### **Appeal A: APP/T2350/W/16/3148964**

#### **Great Mitton Hall, Mitton Road, Mitton, Clitheroe BB7 9PQ**

- The appeal is made under section 78 of the Town and Country Planning Act 1990 against a refusal to grant planning permission.
  - The appeal is made by Mr and Mrs Kay against the decision of Ribble Valley Borough Council.
  - The application Ref: 3/2016/0091, dated 22 January 2016, was refused by notice dated 22 March 2016.
  - The development proposed is a conservatory on the south east elevation of a modern extension.
-

### **Appeal B: APP/T2350/Y/16/3148963**

Scale: 1:50 @ A1
 Date: 6 JAN 2016
 Drawn By: DIANE
 Checked By: G. HOOD
 Drawing: PLANNING
 CONCEPT / PROPOSED
 Drawing No: A13/10554/2.

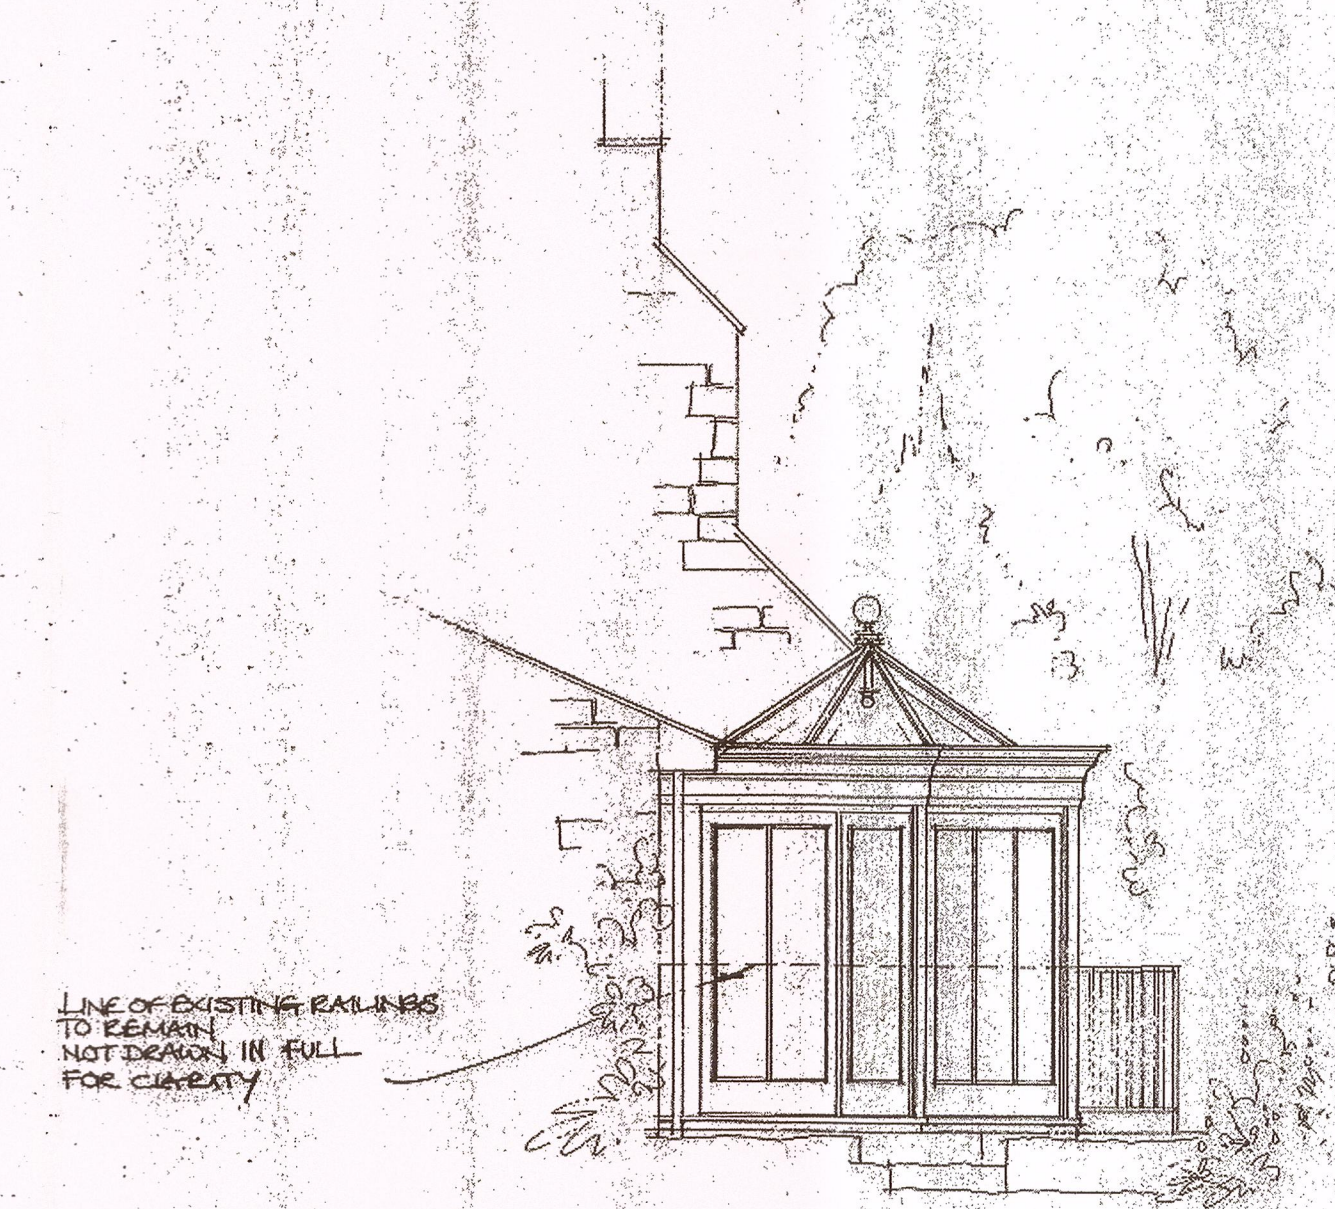
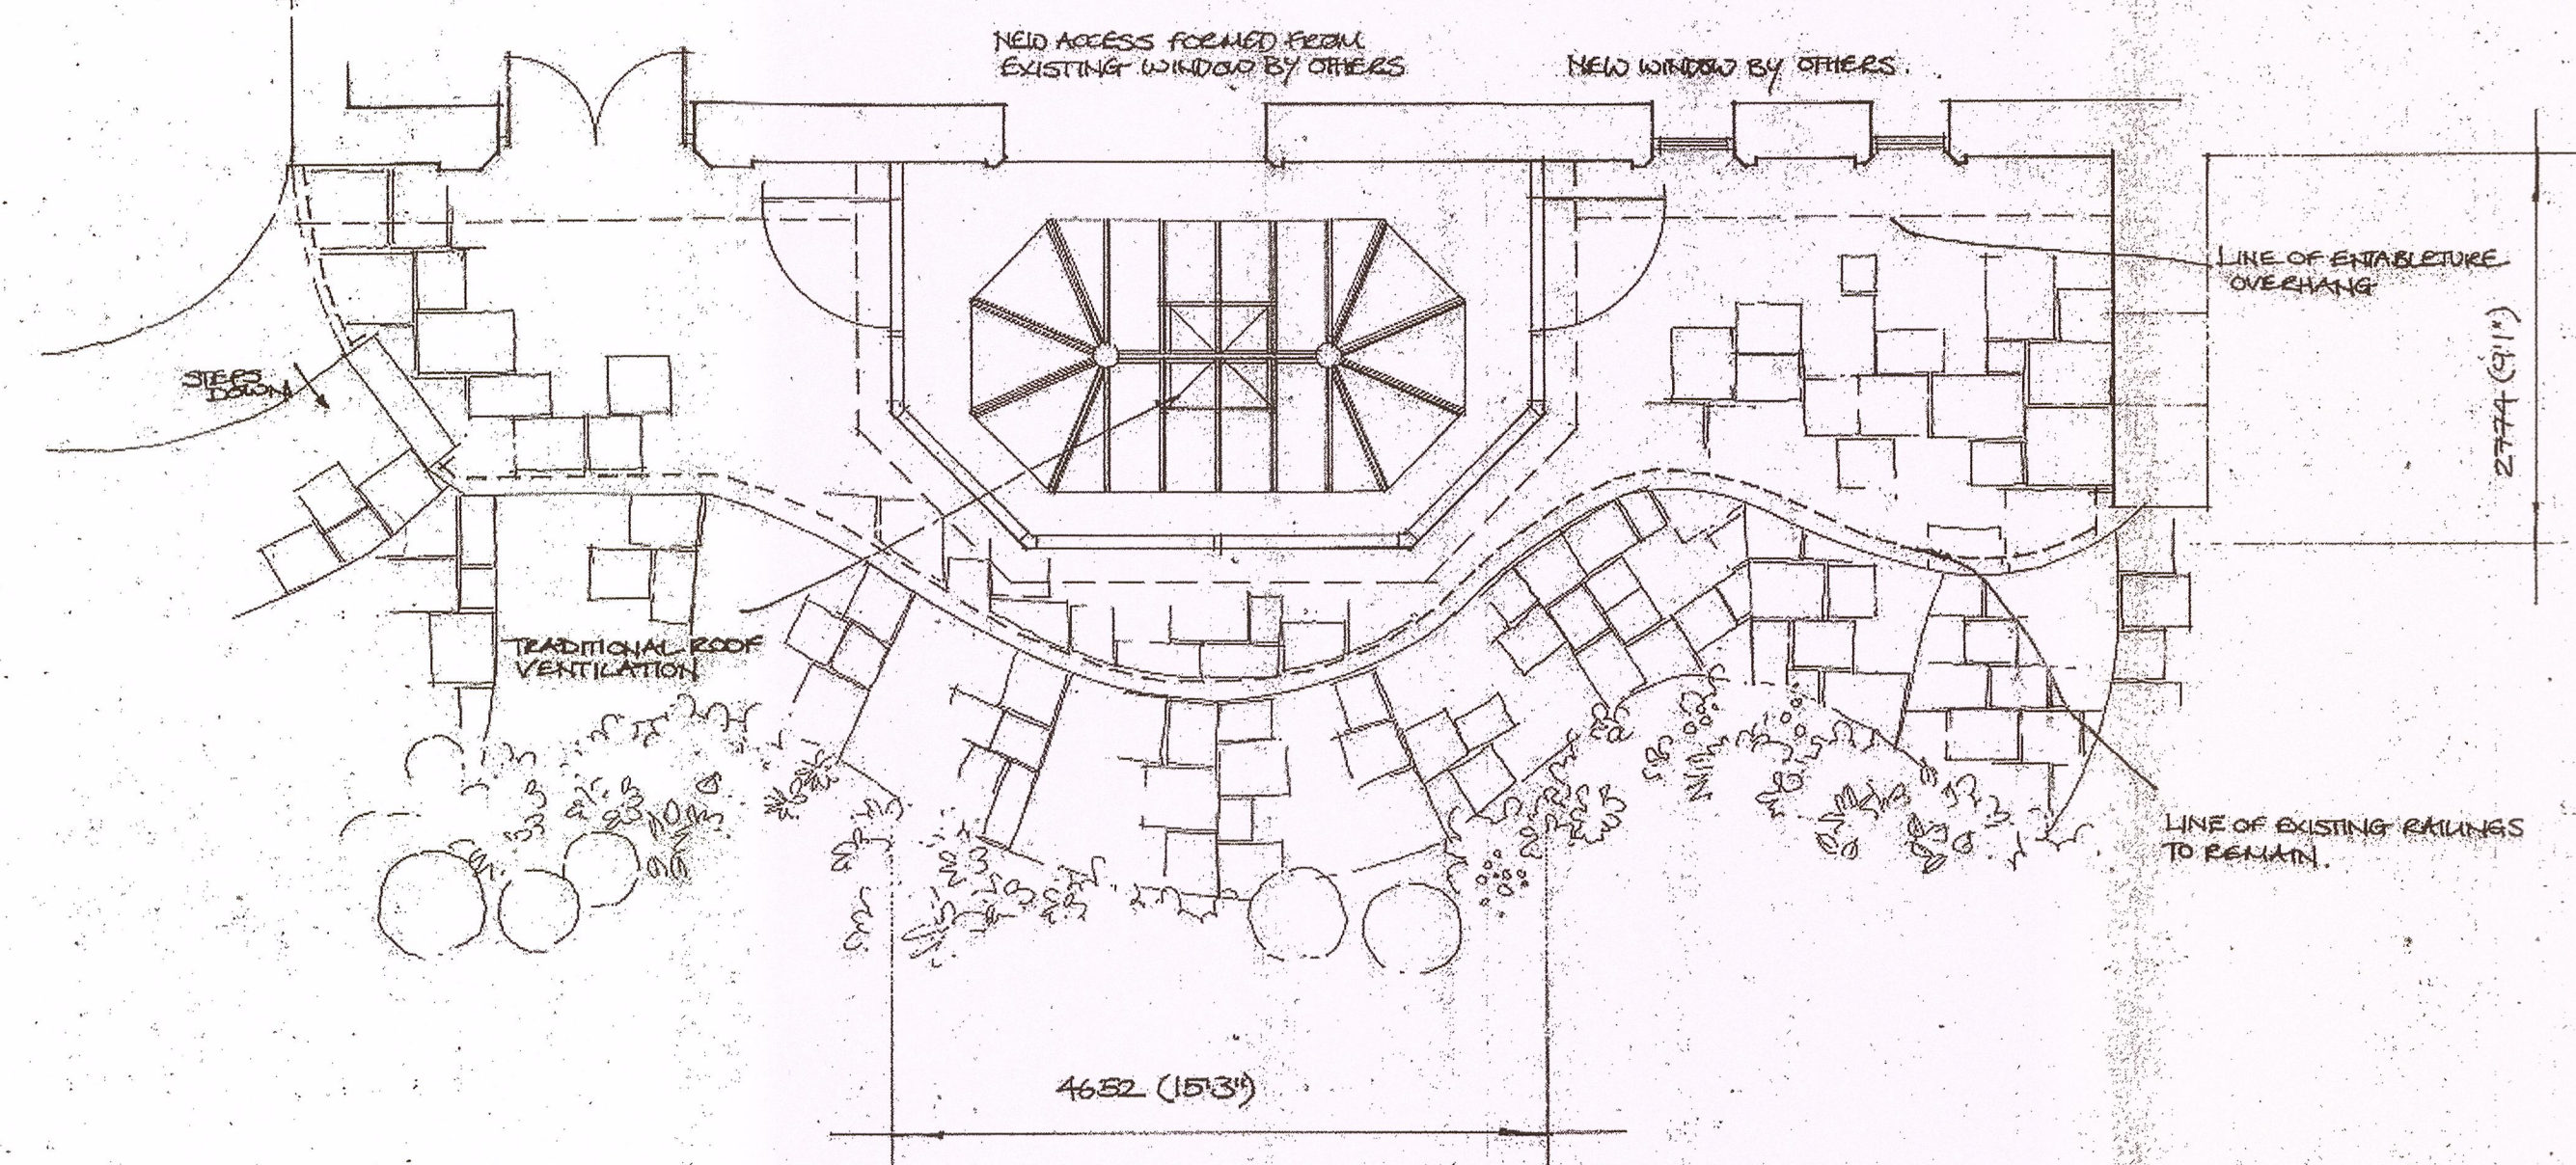
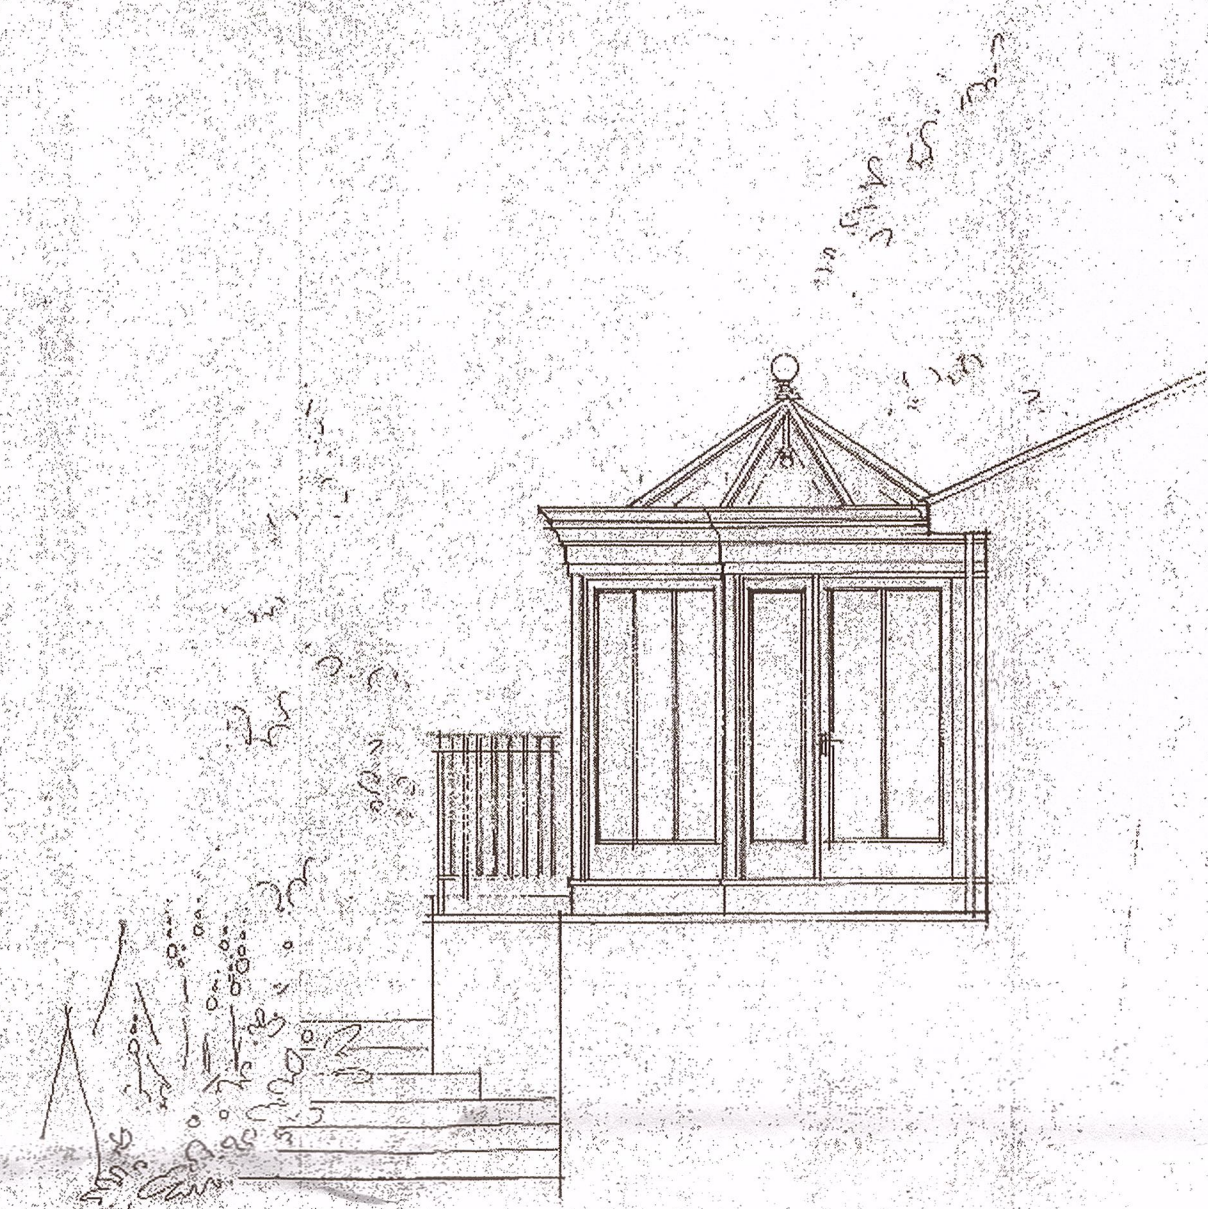
7. The proposal would lead to the construction of a neo-classical style conservatory on the southern elevation of the single storey extension to the original building. It would be located centrally and utilise the existing terrace as a foundation. A number of minor changes would be made to the existing fenestration of the extension and the structure would not extend above the ridge line. Consequently, there would be no loss of original fabric or any change to the original layout of the listed building. However, the introduction of this alien feature would diminish the dominance of the windows of the buttressed gable and undermine their functional role. This is because the conservatory would create a diversionary feature and introduce a new vantage point from which wider views of the landscape to the southwest would be gained. It would also significantly increase the extent of the reflective surfaces associated with the extension during the day as well as the prominence of its illumination at night. Whilst I accept that the latter could be controlled through an appropriate condition, this is not the case for the former. Even if less reflective glass was used the overall extent of the reflective surface would still remain unacceptable.

8. Notwithstanding the modern origin of the extension, the proposed structure would introduce a highly incongruent feature that would lack sympathy with the simple architectural form and period detailing of the original building. This harm would also erode the setting of the church given the prominence of the conservatory within the asset grouping. Given the above, I find that the proposal would fail to preserve the special interest of the listed building as well as the setting of the nearby listed church. I consequently give this combined harm considerable importance and weight in the planning balance of this appeal.
